**Transport
for NSW**

Notice of Exhibition: Stage 1A Public Domain Works, Barangaroo South (SSD 6303)

Thank you for your letter dated 27 May 2014, requesting Transport for NSW (TfNSW) to review and comment on the subject proposal. Please accept this letter as a joint Roads and Maritime Services (RMS) and TfNSW response to the subject proposal.

DRAWING
Section HH - Hickson Place

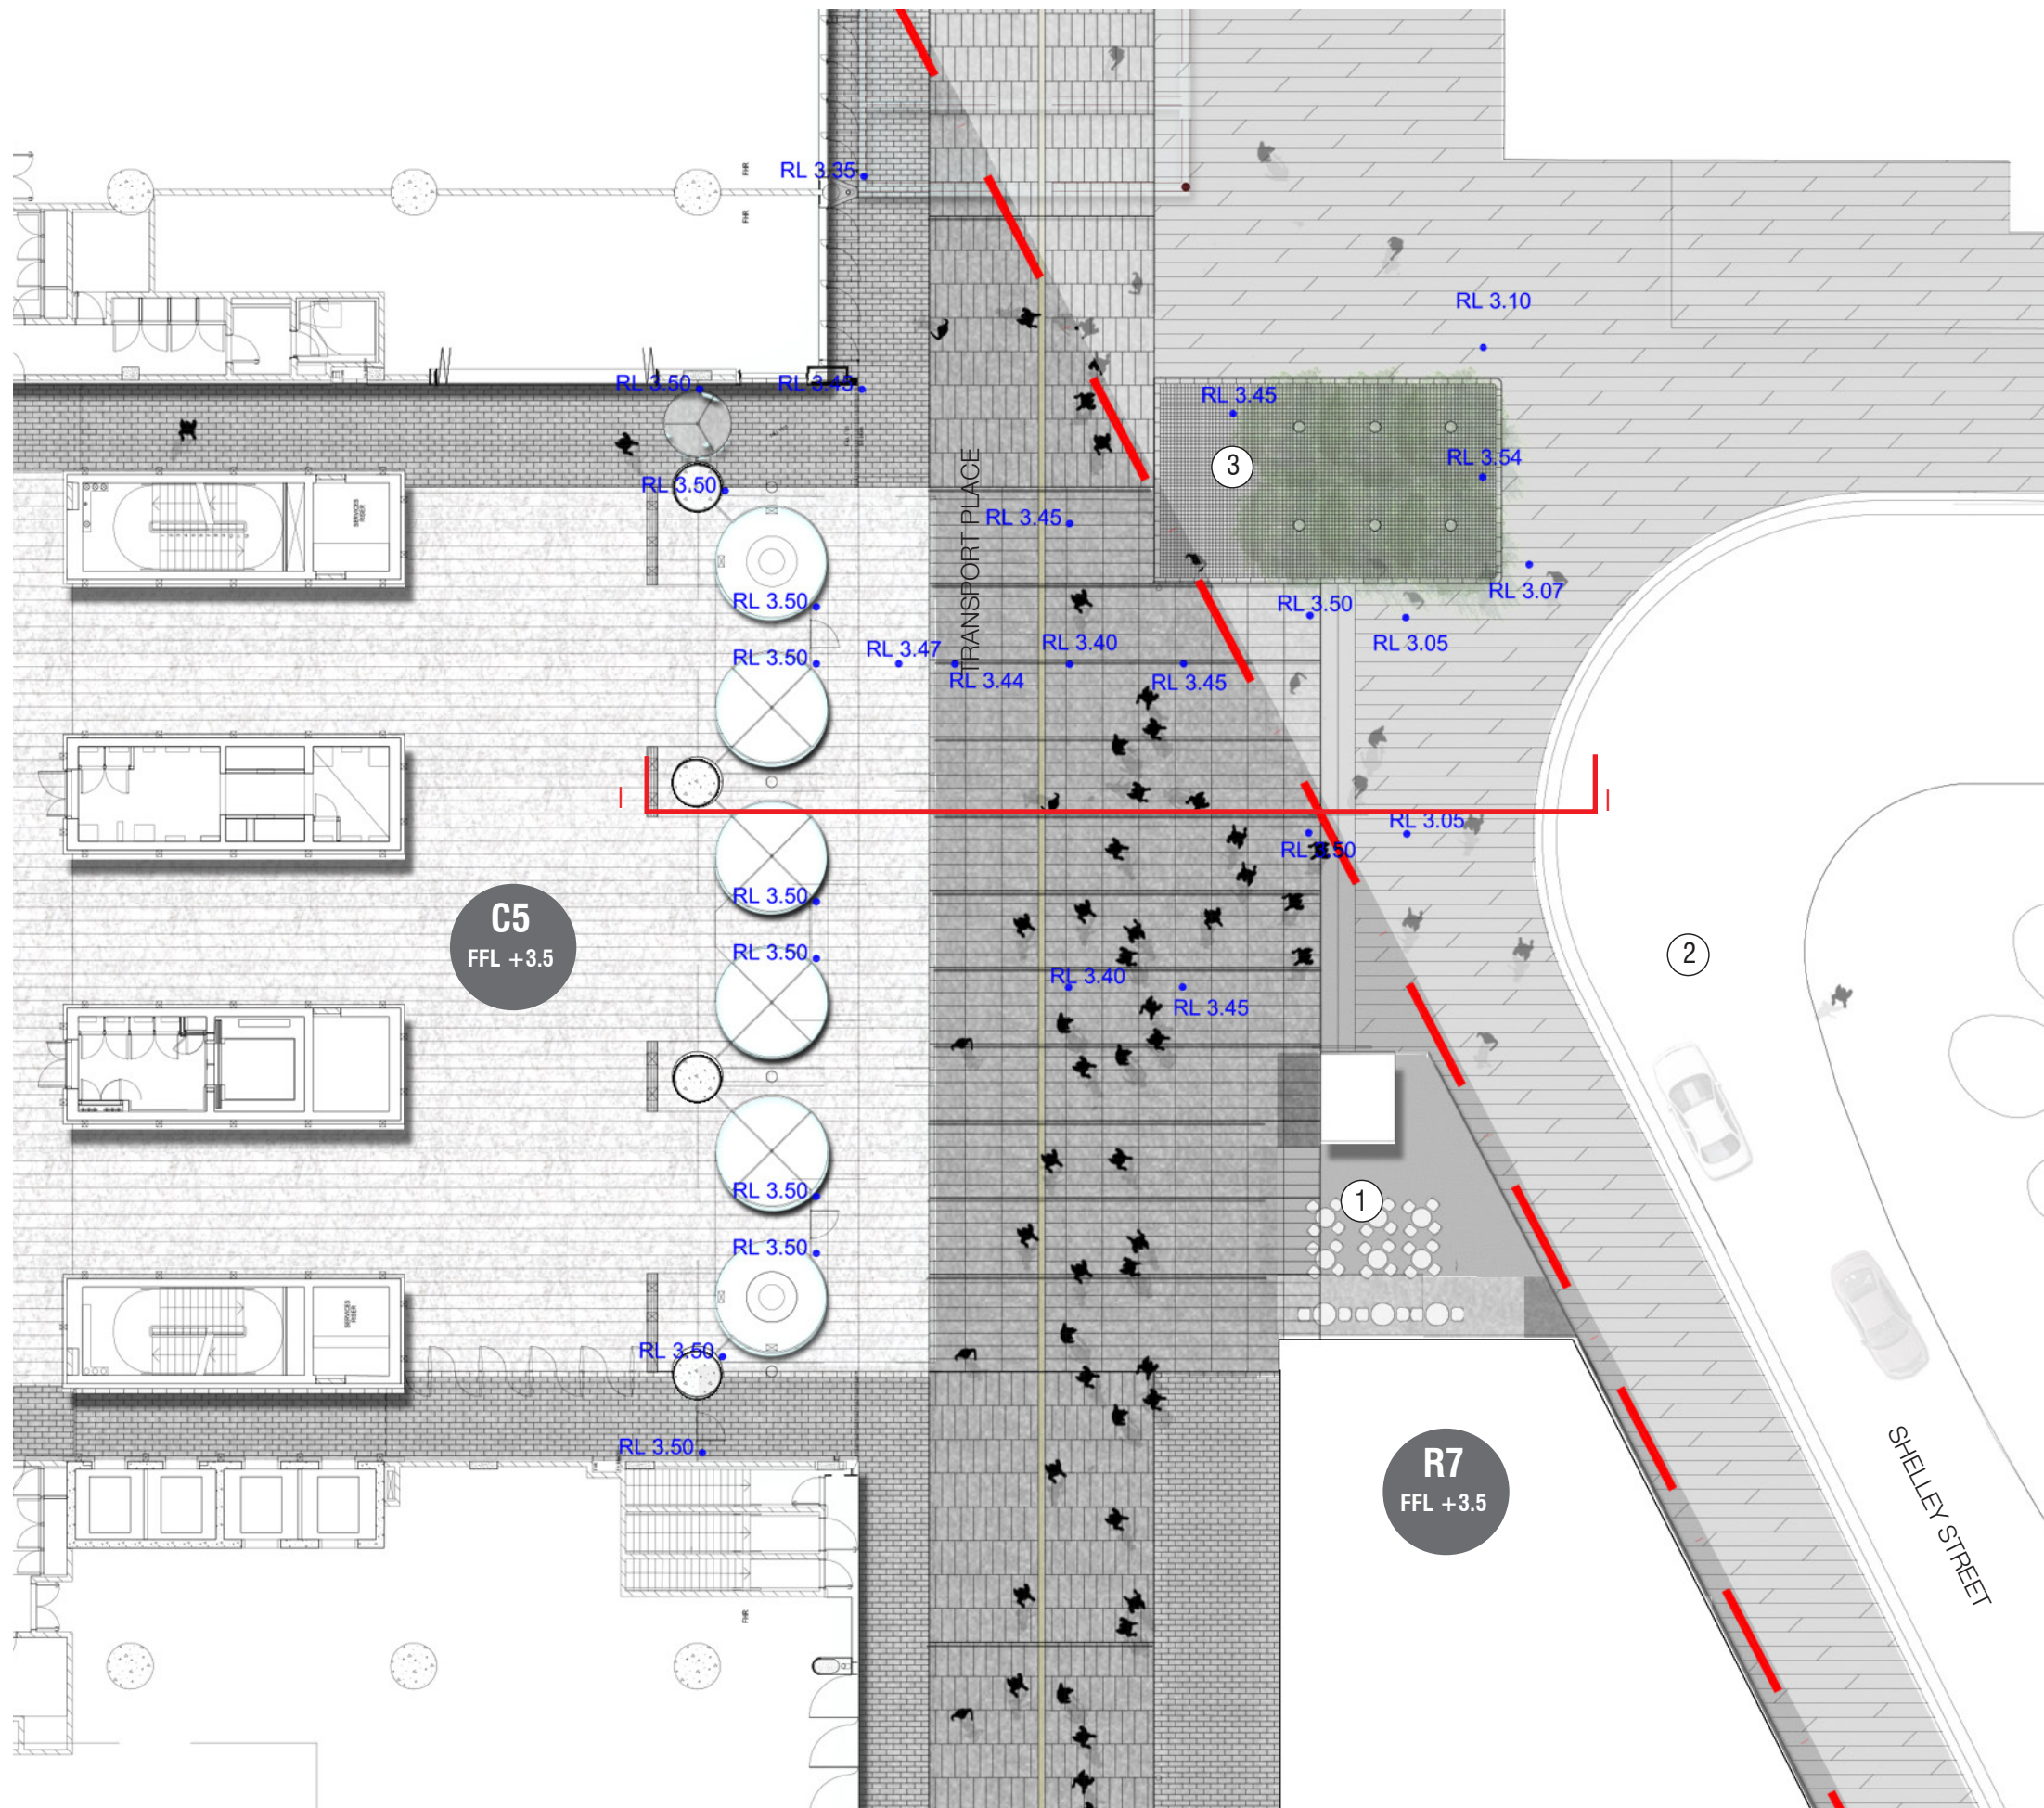
- The ramp grade at the southeast corner of the site is shown at 1:36 with a drop in level of +2.88 to +2.5 towards King Street Wharf. The ramp does not appear to dovetail with the ramp drawing shown in Civil Drawing BPO CD0000013/11. TfNSW requests that ground levels at Hickson Place and the eastern end of Transport Place be coordinated with the Wynyard Walk project team.

Figure 7: Globe Street North / Hickson Road intersection

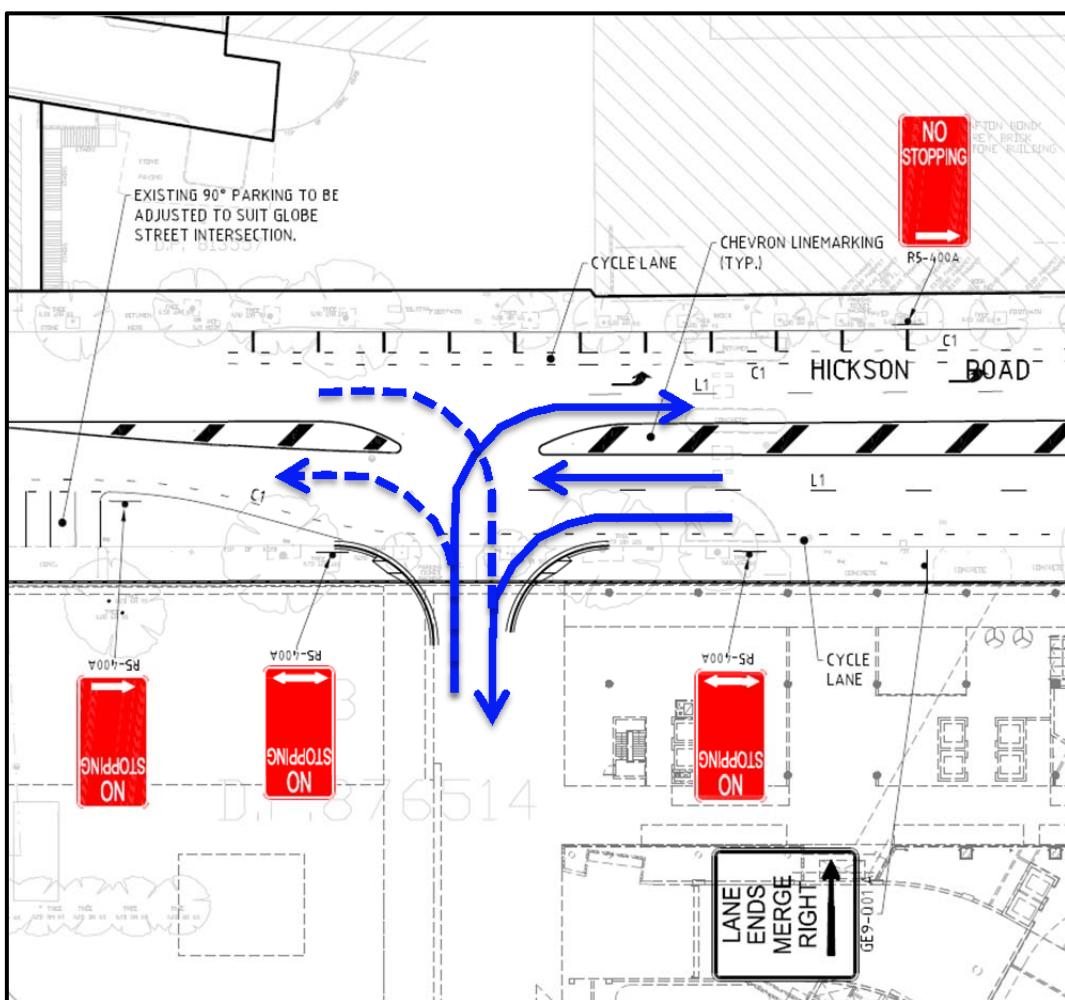
- The proposed intersection arrangement at the Hickson Road/Globe Street North intersection allows one travel lane and a parking lane on the eastern side of Hickson Road based on Figure 7 of Appendix F. This arrangement would have the potential to block bus movements by the right turning vehicles from Hickson Road onto Globe Street North and cause delays to buses as well as general traffic. TfNSW requests that the proponent assesses the impacts on bus movements at this intersection and propose mitigation measures for the impacts identified.

Figure 9 Future City Centre Strategic cycleway and pedestrian access improvements

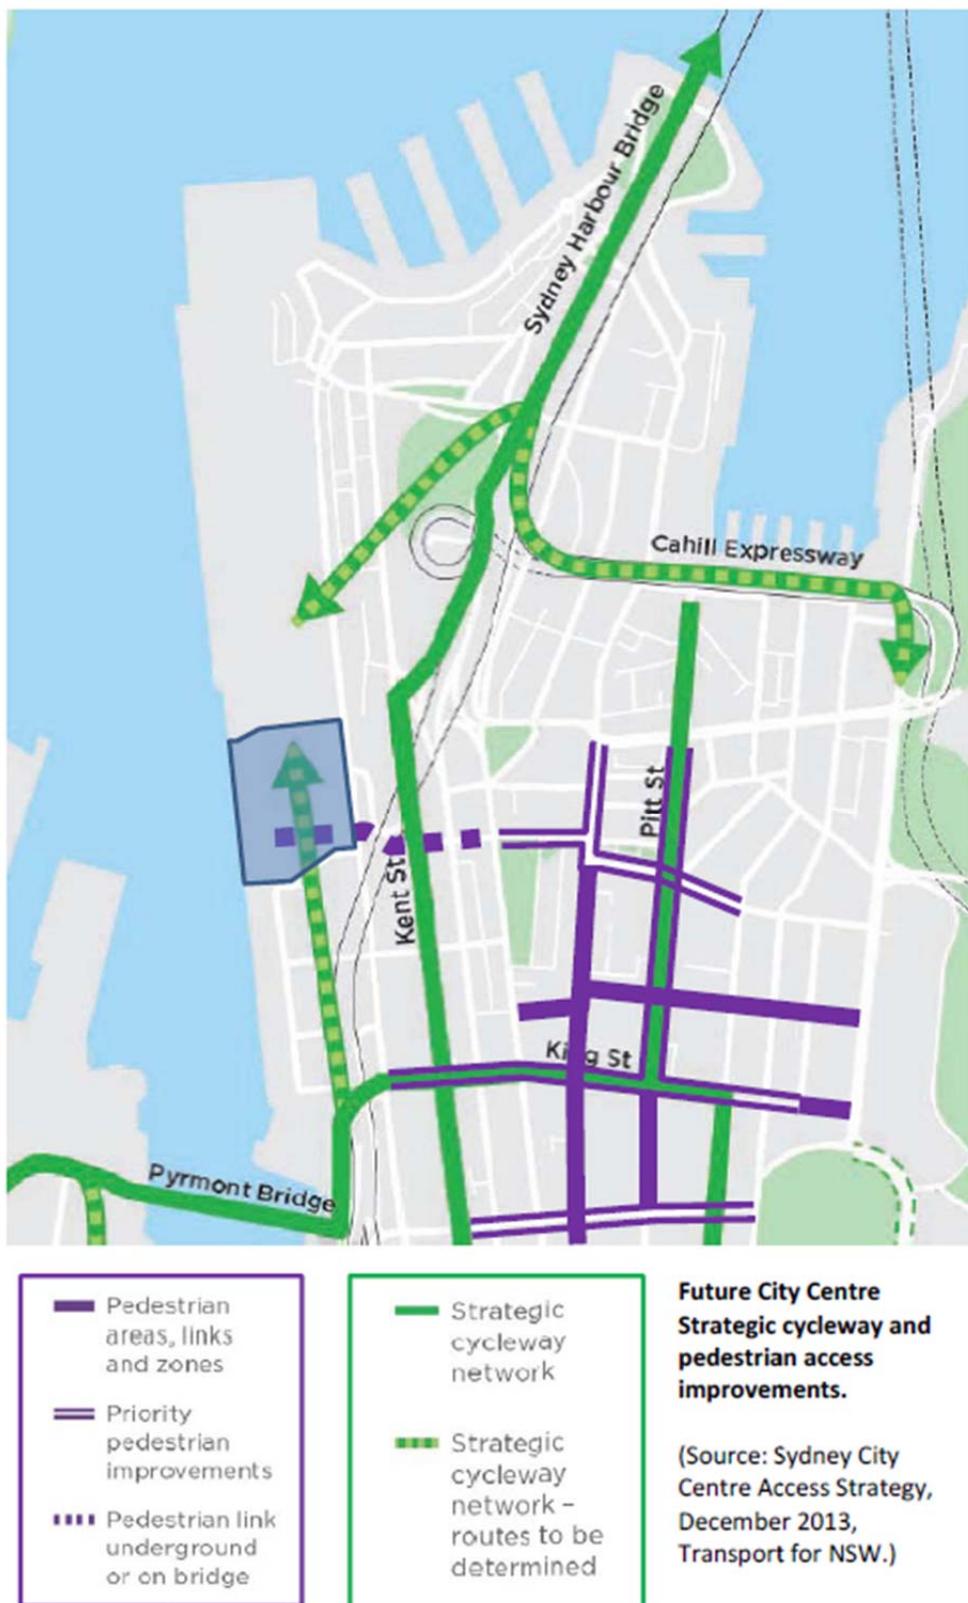
- The Sydney City Centre Access Strategy diagram is provided at Figure 9 of Appendix F of the EIS for reference whilst the EIS does not show the southern strategic cycle connection as shown in the Sydney City Centre Access Strategy. Appendix F of the EIS incorrectly states that Barangaroo South is well connected to cycleway networks.

Proposed connections to cycle network are still to be determined. The responsibility of the proponent is to develop the connections to the strategic cycleway network in liaison with TfNSW. TfNSW requests that connections between Barangaroo South and the strategic cycle network be developed, in consultation with TfNSW, to address the Sydney City Centre Access Strategy.
